**From:** [Rodgers, Deborah \(CONTR\) - TERR-TRI CITIES RMHQ](#)  
**To:** [Jamey Ayling](#)  
**Cc:** [Connell, Valorie L \(BPA\) - TERR-PASCO](#)  
**Subject:** DV-24-00001 Ranch on Swauk Creek Notice of Application  
**Date:** Friday, July 26, 2024 3:54:31 PM  
**Attachments:** [image001.png](#)

In reply refer to: 24-00001 Ranch on Swauk Creek Notice of Application

Tract Nos.: R-MV-49-A-176, R-MV-49-A-175, R-MV-50-A-177A  
Line Names: Rocky Reach-Maple Valley No. 1  
Structures 48/4 – 50/1

P.U.D. Master Site Plan

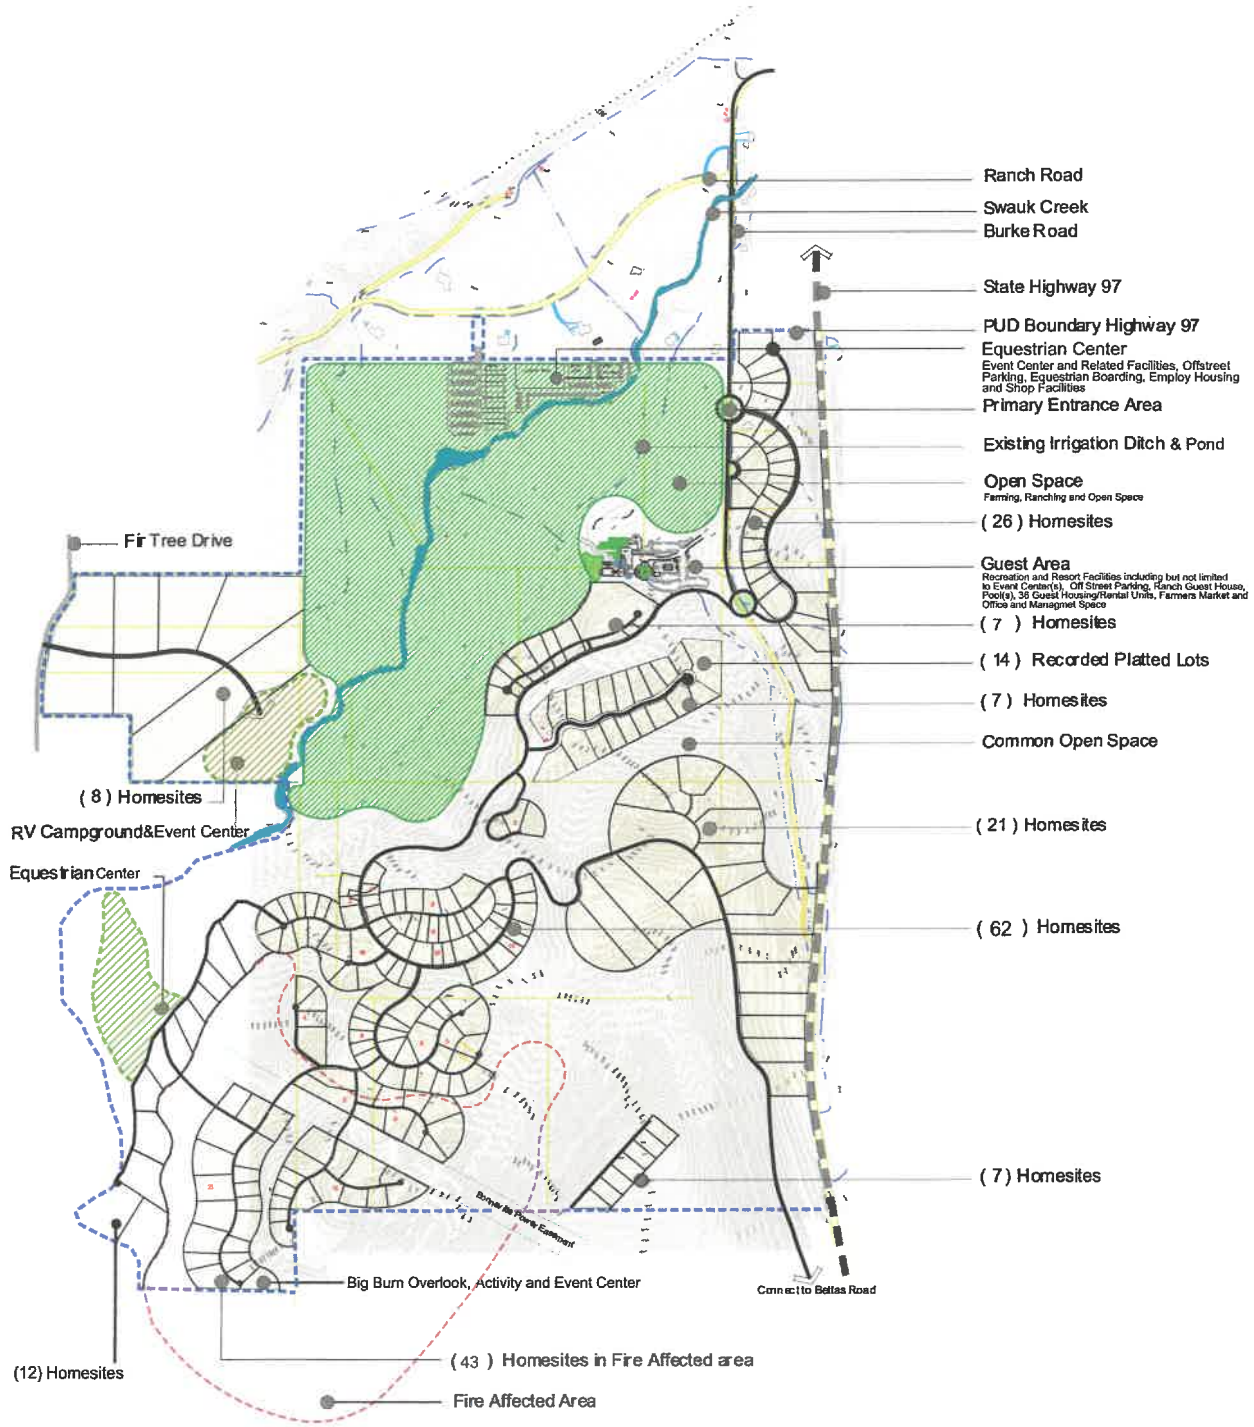
BPA easements are taken with certain restrictions on the underlying land. In order to maintain operation and safety criteria, all activities planned within the BPA easement need to be approved by BPA prior to their occurrence. Activities that block maintenance crews (such as the installation of fences) or safety concerns (such as buildings, driveways, utilities, or small structures) need to be addressed prior to construction in order to avoid later modification, at the landowner's expense.

In addition, BPA needs the opportunity to review the location of proposed roads to ascertain whether or not the clearance here allows for safe passage of vehicles (per National Electric Safety Code). This process takes up to 9 months to complete and is typically initiated by a land use application that the developer or landowner submits to BPA.

Whether or not this property is subdivided and/or this plat approved, the owner will need to submit a land use application, the associated application fee and acquire a Land Use Agreement from BPA, along with the county's building permit for any portion of the owner's development plans that lie within BPA's easement.
